Department of Primary Industries

OUT13/6876

**Cobbora Coal Project (MP10_0001)
Comment on the Response to Submissions and Preferred Project Report**

Cobbora Coal Project (MP10_0001) Response to Submissions and Preferred Project Reports

Flood Impact Study Zones

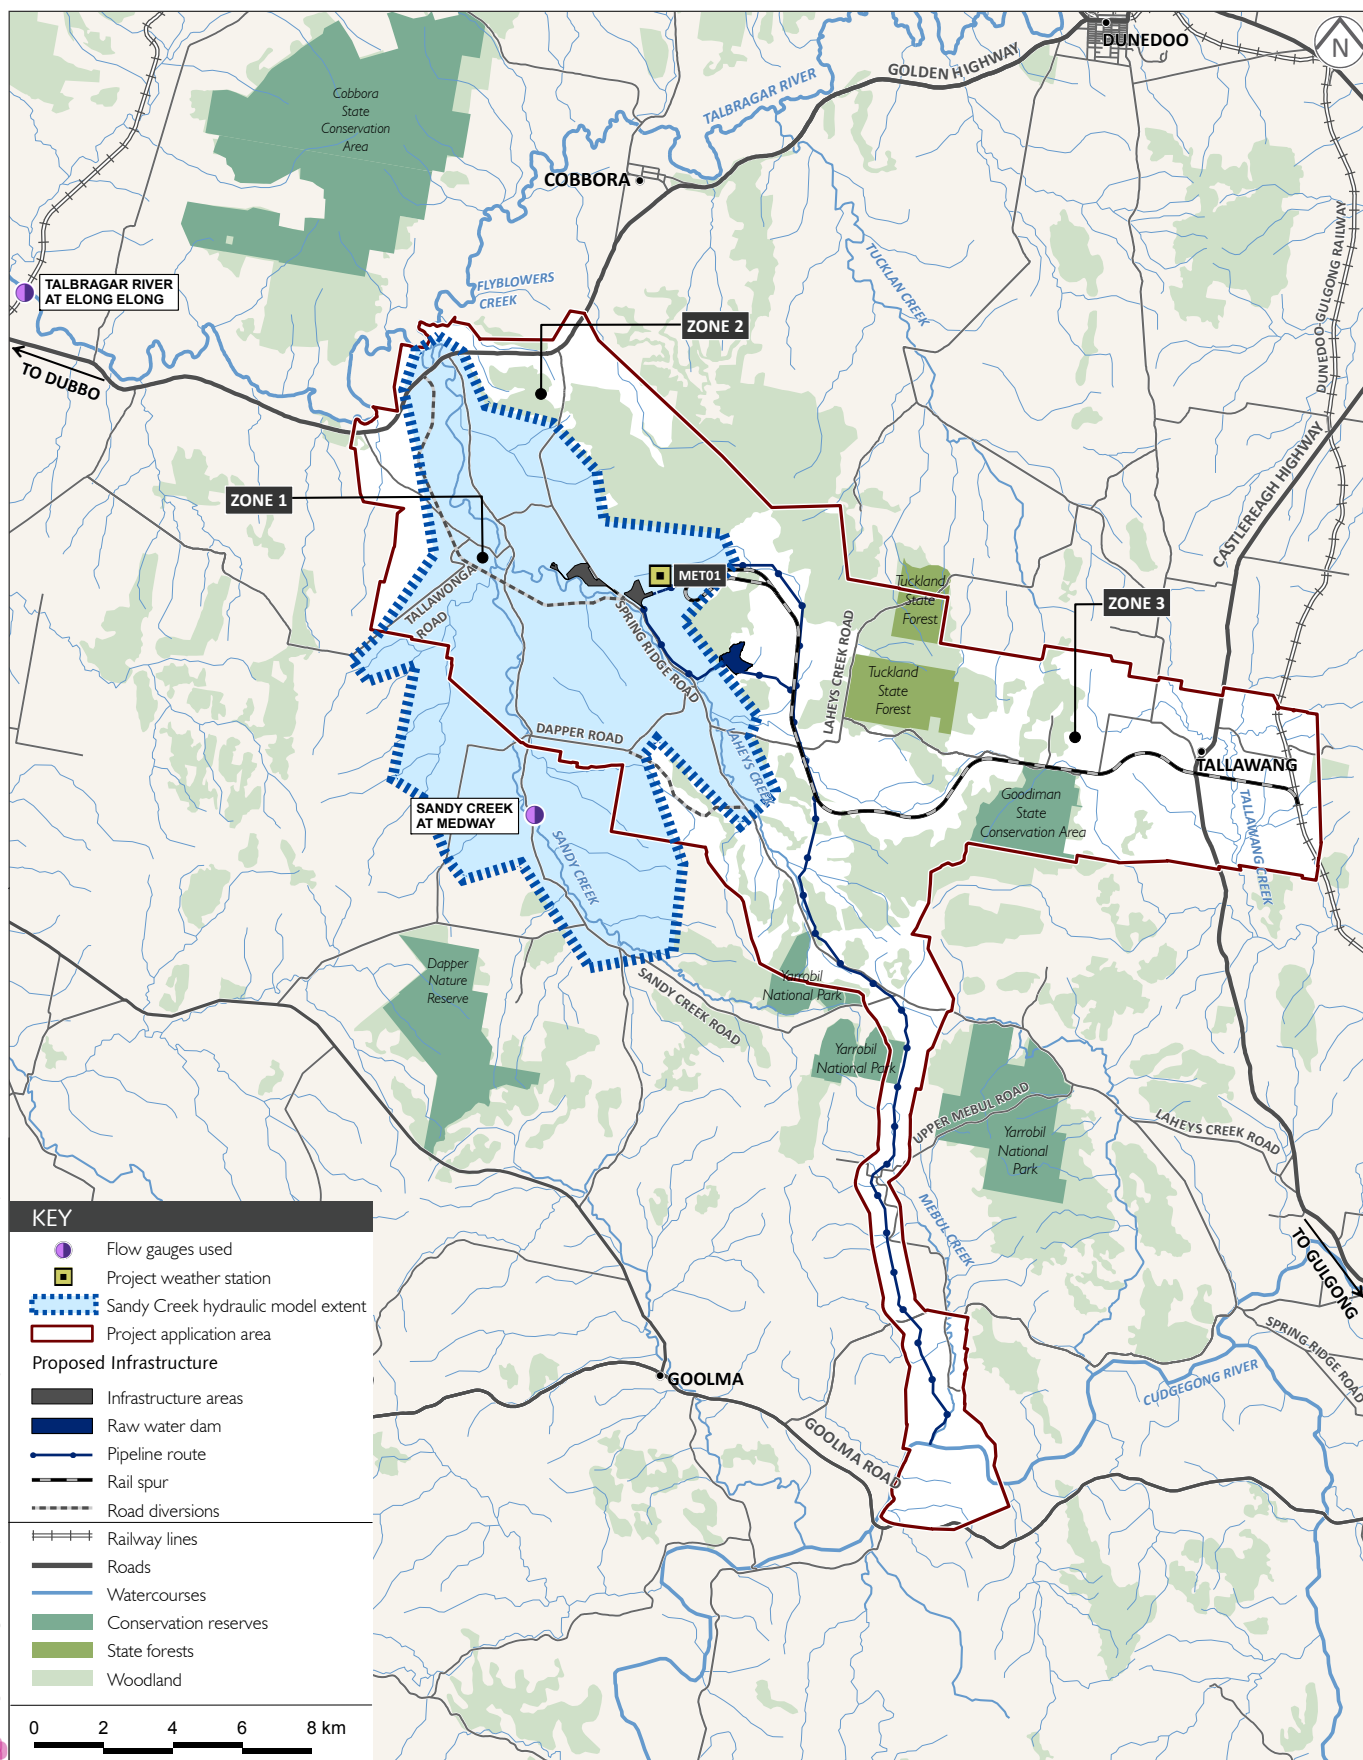
- The main flooding impacts identified in the PPR include:
 - increased flooding of Flyblowers Ck near the current Spring Ridge Rd and Golden Highway watercourse crossings.

- localised increases in flooding on the project site adjacent to Laheys Ck and the lower reaches of Blackheath Ck. Impacts on Sandy Ck are restricted to near the junction of Laheys Ck.

- localised flooding and increased velocities are predicted around proposed structures within the channel and floodplain. These structures will require mitigation measures to either reduce velocities or provide erosion protection to ensure channel and floodplain stability.

Water Management System Concept for Year 20

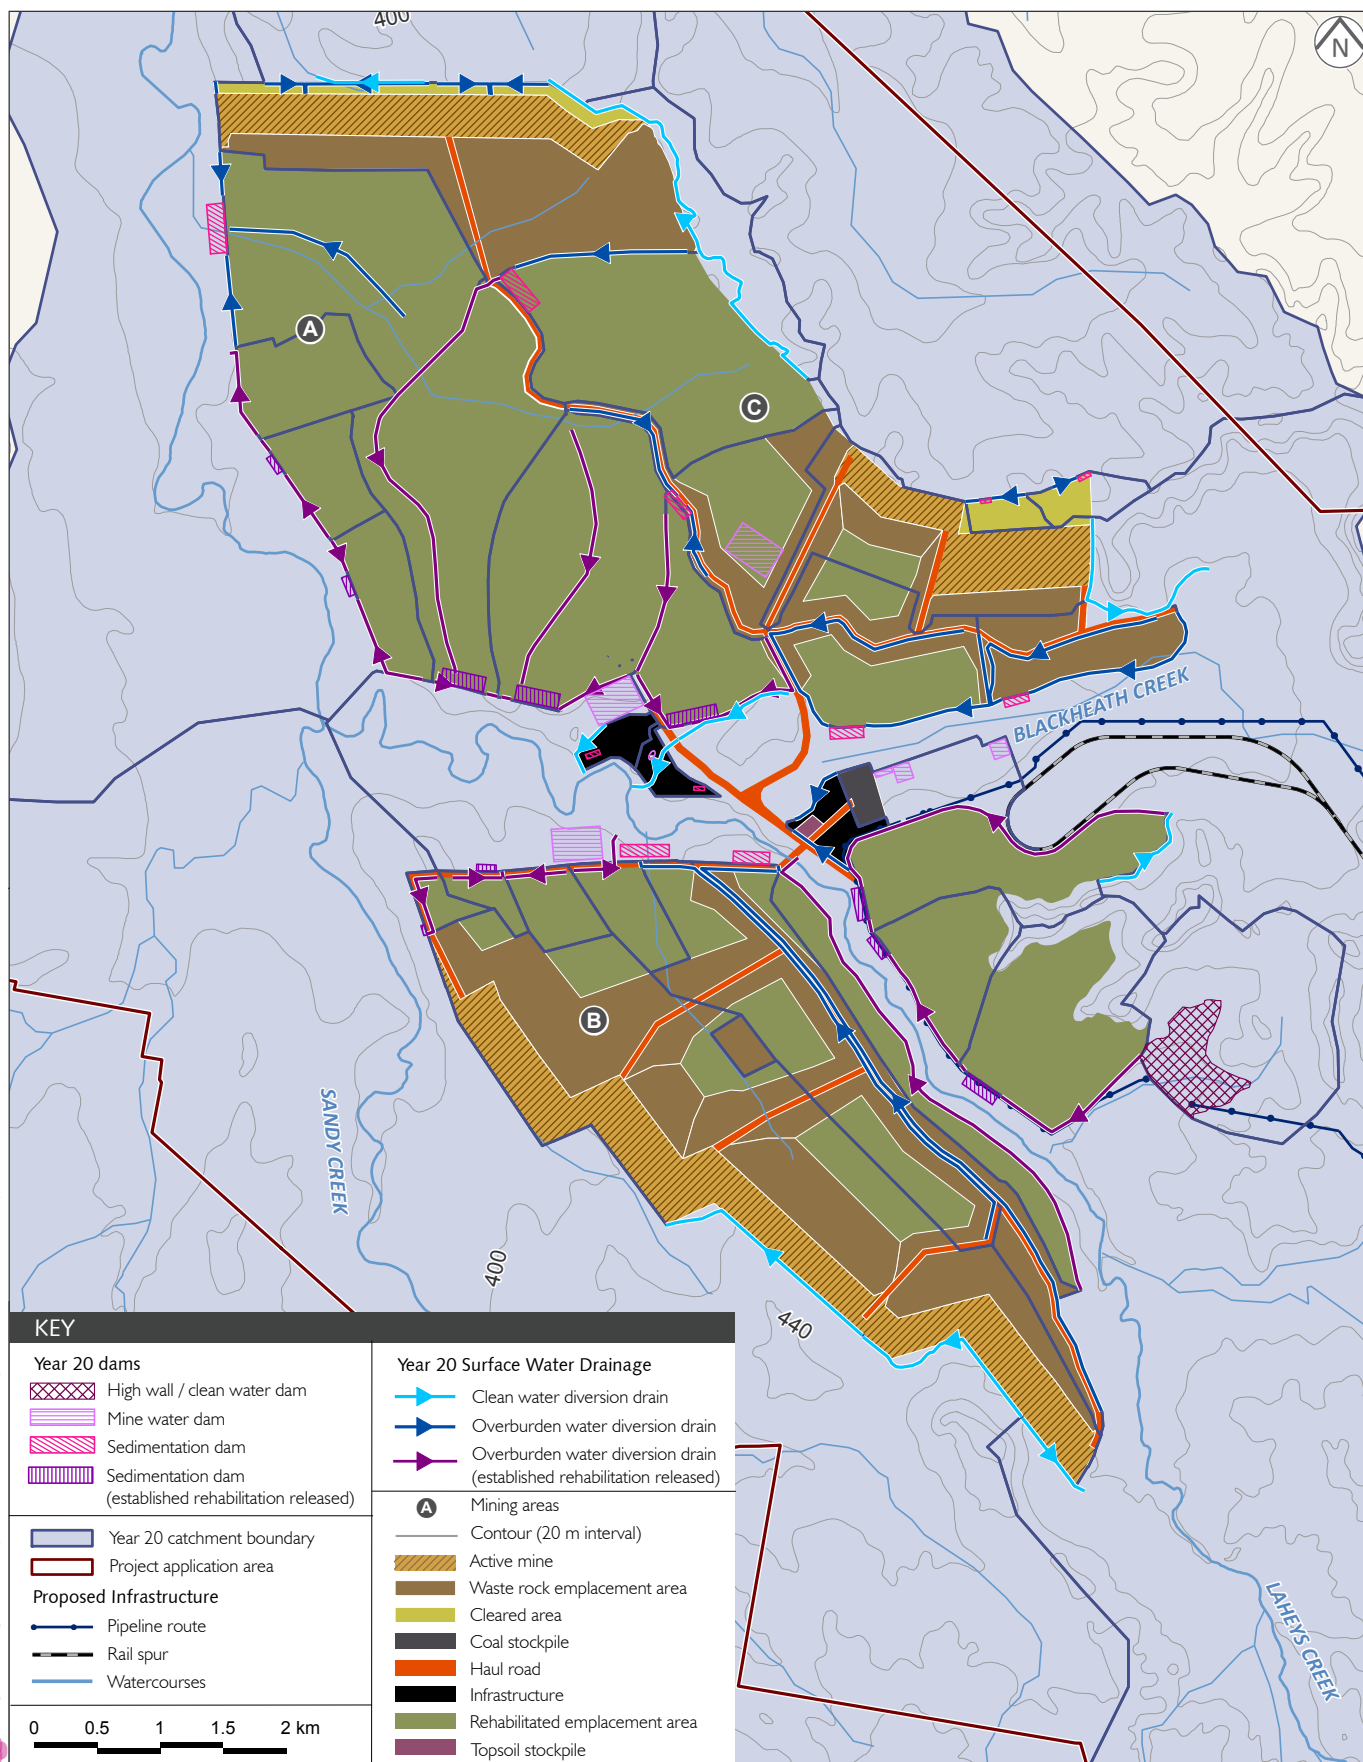
- (vi) The proposed modifications to the Woolandra West Dams requires further clarification in terms of proposed works during construction, mine operation and post mine life. Further conceptual detail is necessary to understand the scale of works, potential impacts, licensing implications and long term proposed functioning of the local surface water system.

- The surface water assessment has assumed the runoff to the existing Woolandra dams will be returned to Laheys Ck. The exact staging and design has not been confirmed in the EA. This reinstatement of flows is proposed to offset the reduction in area from the void in mining area B proposed at completion of mining.

- The proposal to modify the Woolandra dams will require an amendment and potential cancelling of the existing licence held under the *Water Management Act 2000*. The exact procedure for these licence changes requires the proponent to consult with the NSW Office of Water and provide further detail with regard to the proposed dam modifications, staging and final designs.
